Acceptance of Applications Checklist

Oaklands Farm Solar Park Section 55 Acceptance of Applications Checklist

Section 55(2) Acceptance of Applications				
1	Within 28 days (starting day after receipt) the Planning Inspectorate must decide whether or not to accept the application for Examination.	Date received	28 day due date	Date of decision
		8 February 2024	7 March 2024	5 March 2024
Section 55(3) – the Planning Inspectorate may only accept an application if it concludes that:		Planning Inspectorate comments		
Section 55(3)(a) and s55(3)(c): It is an application for an order granting development consent				
2	Is the development a Nationally Significant Infrastructure Project ¹ (NSIP) (or does it form part of an NSIP); and does the application state on the face of it that it is an application for a Development Consent Order ² (DCO) under the Planning Act 2008 (the PA2008), or equivalent words? Does the application specify the development to which it relates (i.e. which category or categories in ss14 to 30 does the Proposed Development fall)?	<p>Yes</p> <p>The Proposed Development set out in Schedule 1 of the Draft DCO (Doc 3.1) includes development falling within the categories i

Drawing Title
**EN010122/APP/2.4 - Streets, access
and Public Rights of Way Plan
Sheet Overview**

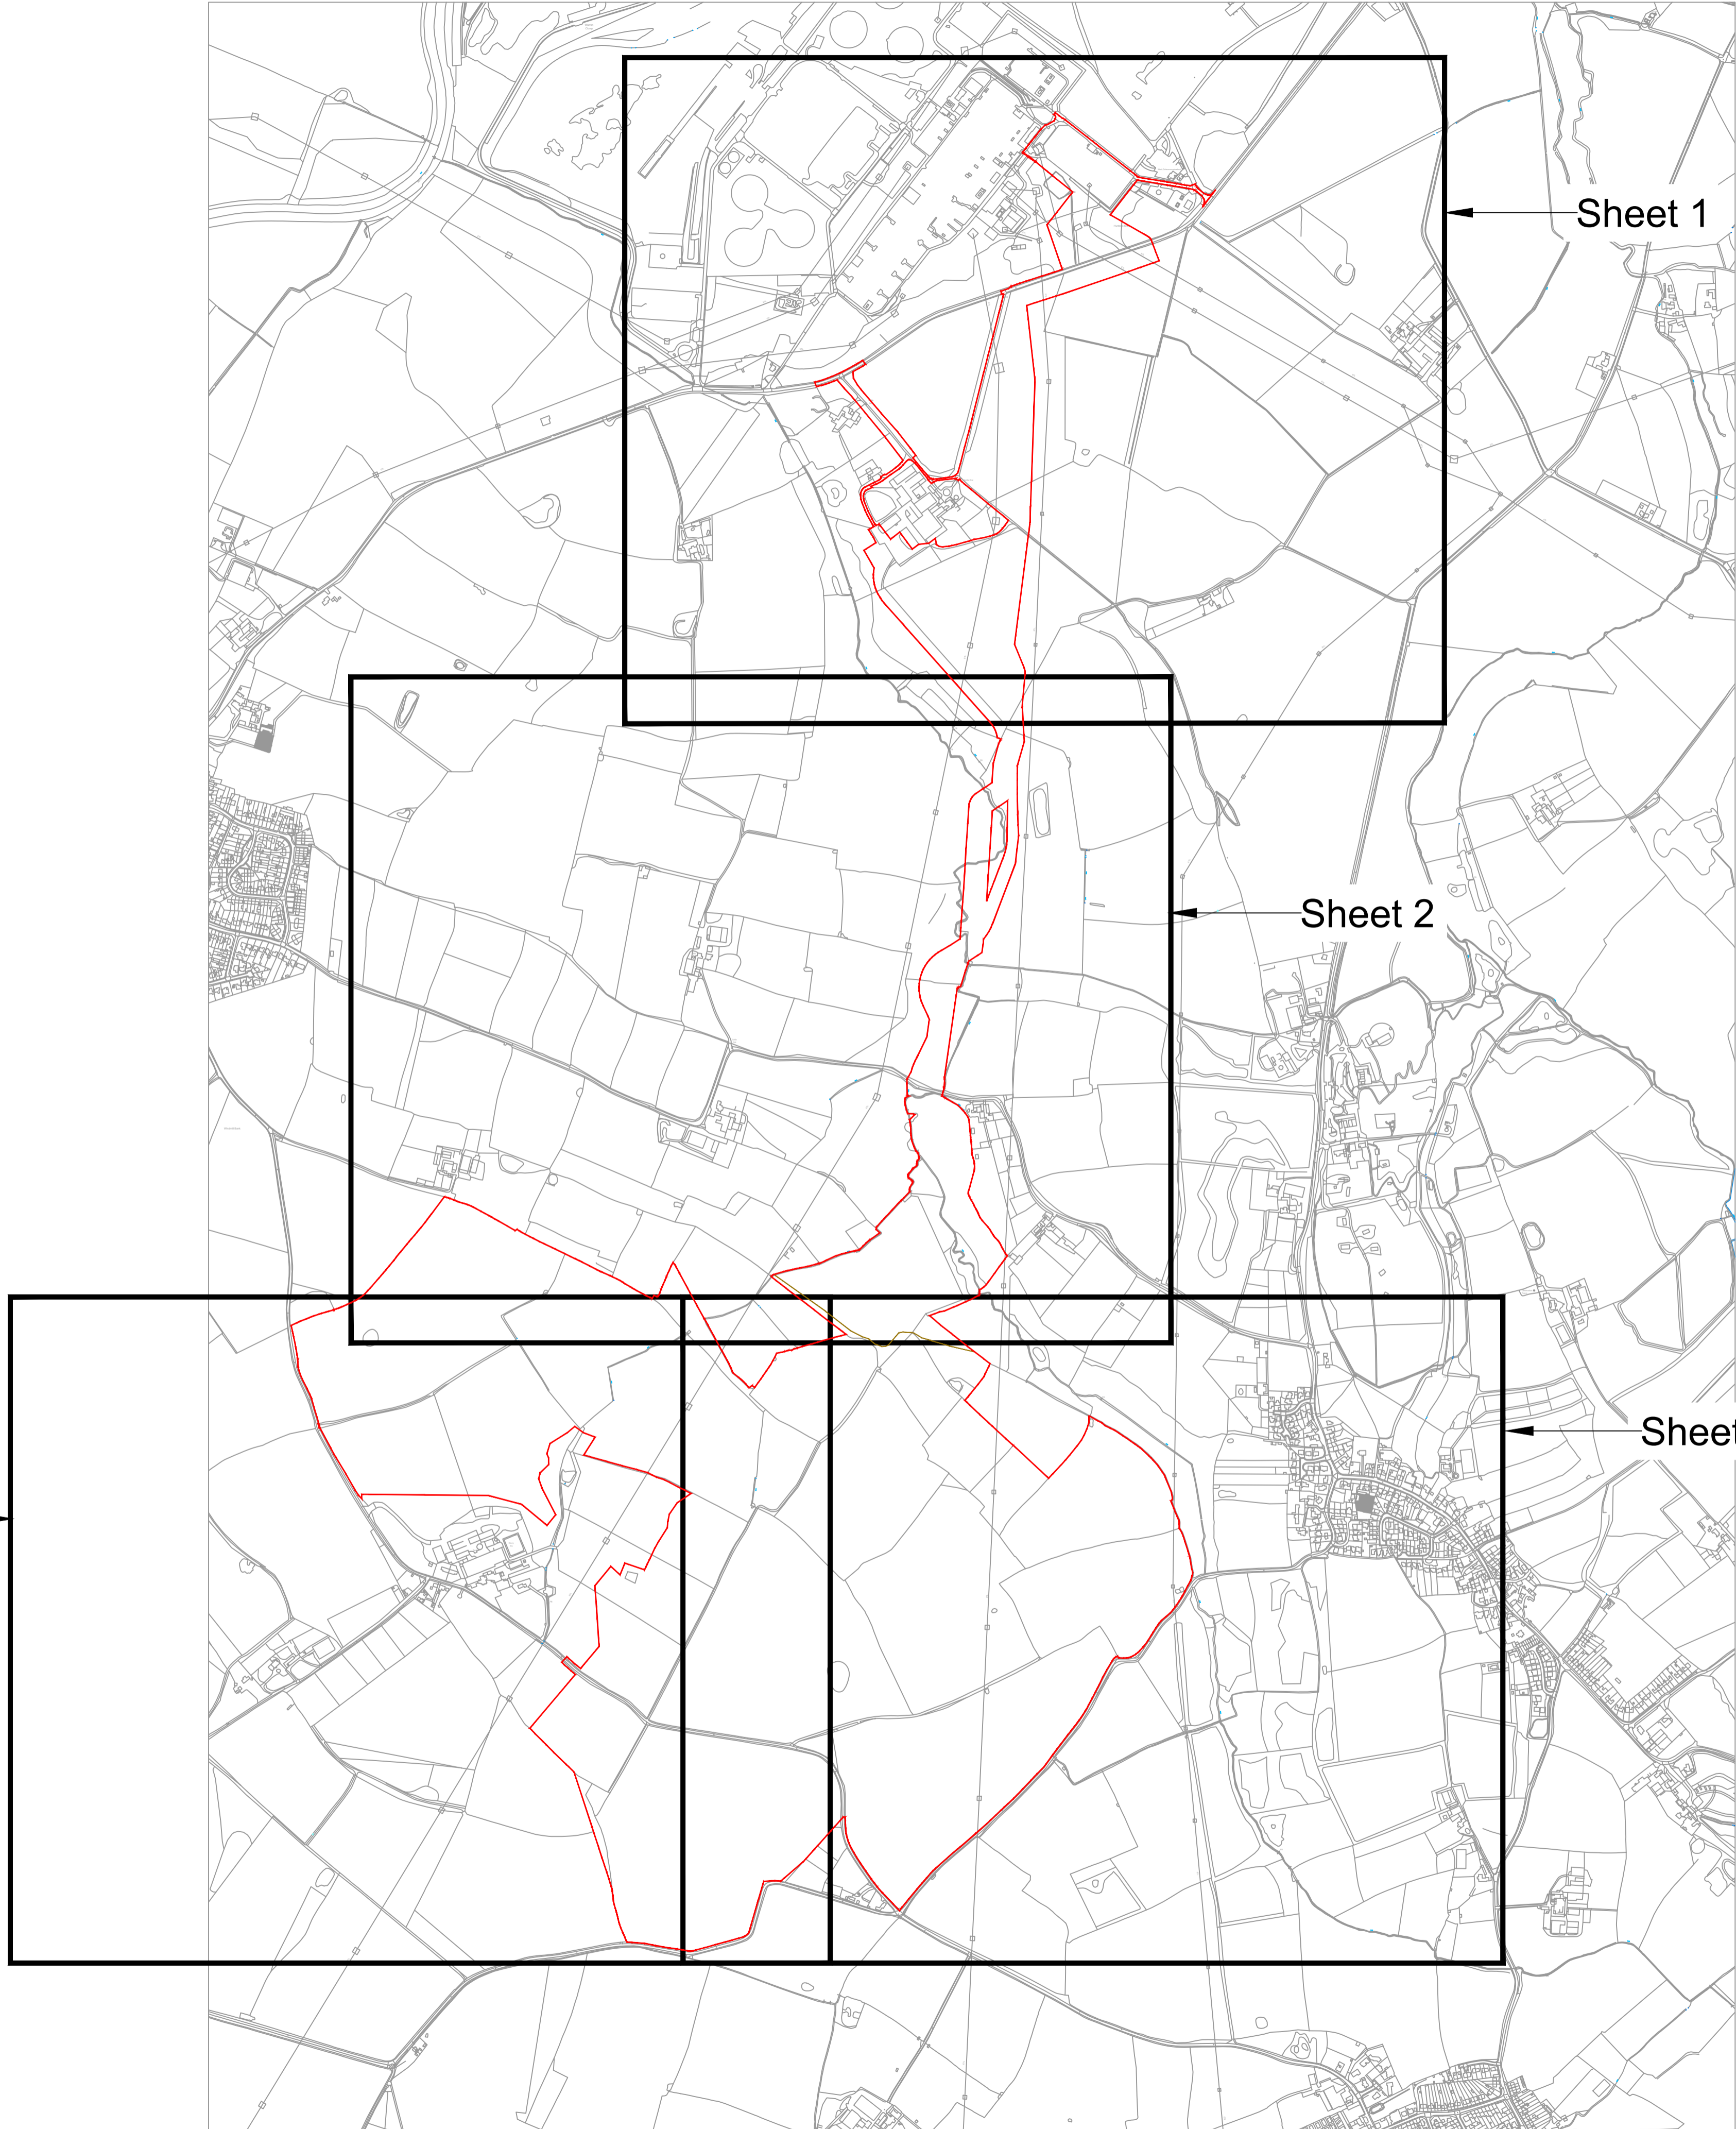
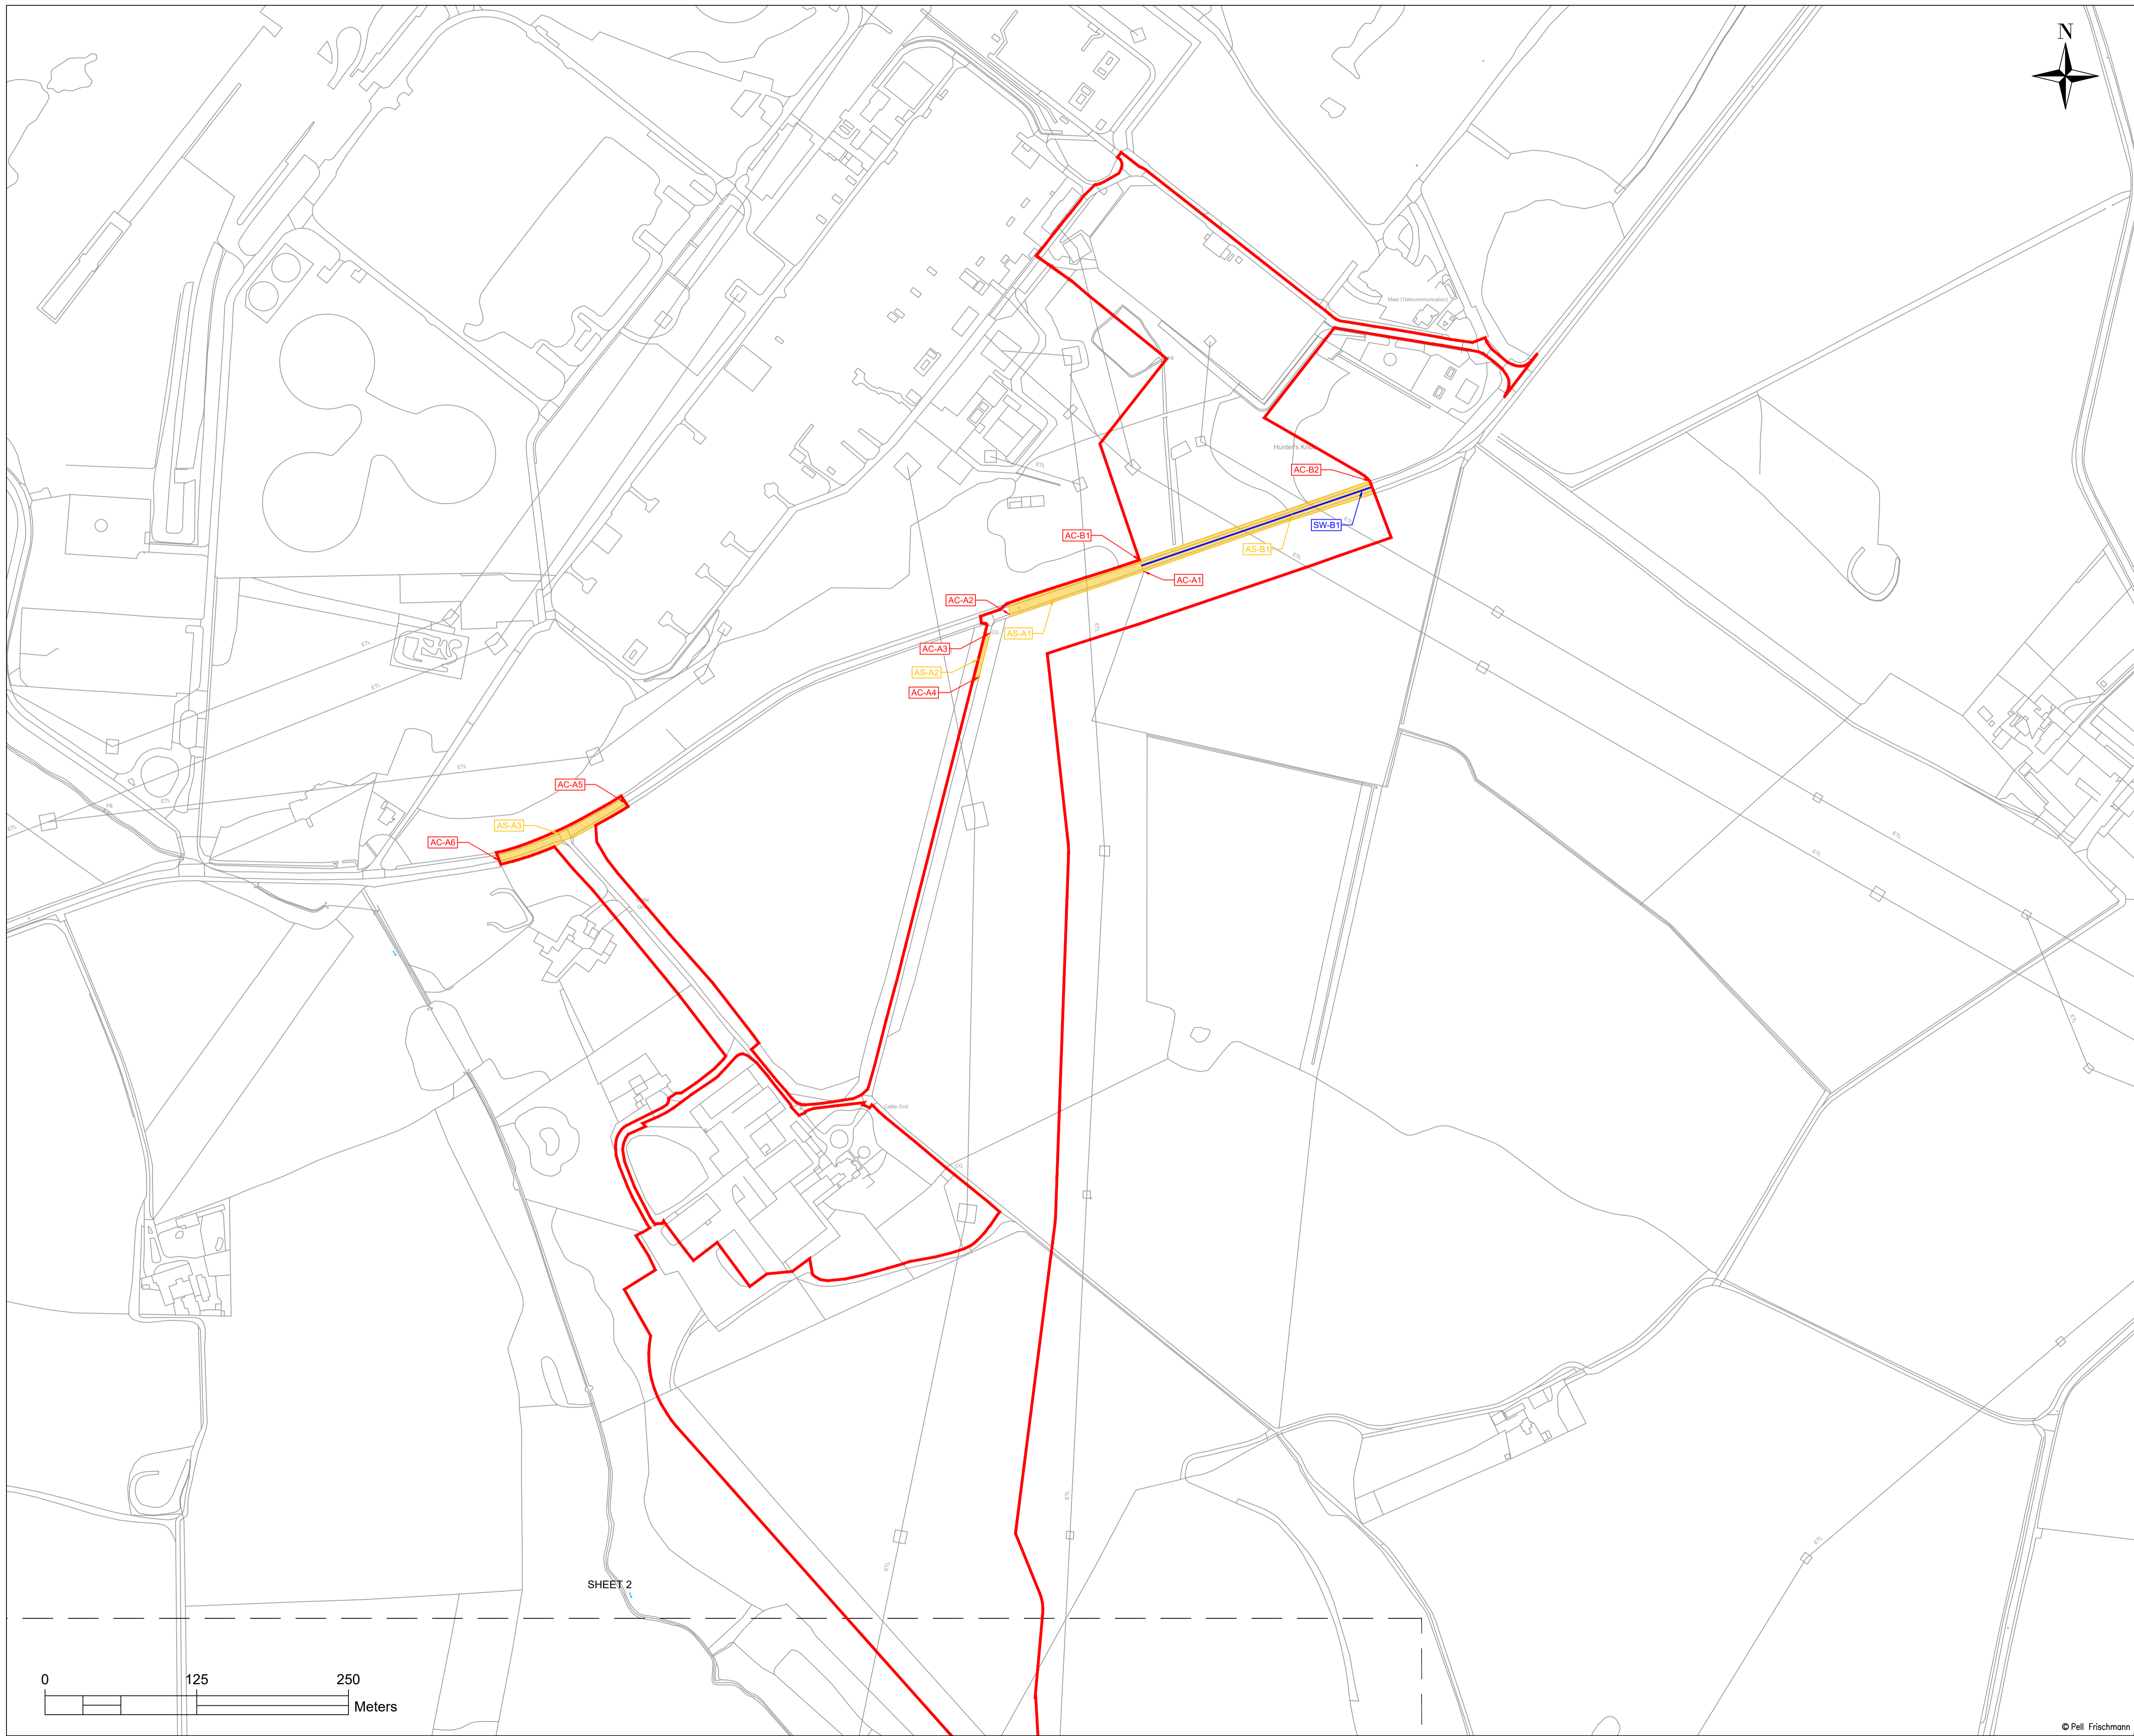
AS-A2 marked on Sheet 1 of the Streets, Access and Rights of Way Plan is omitted from Schedule 4.
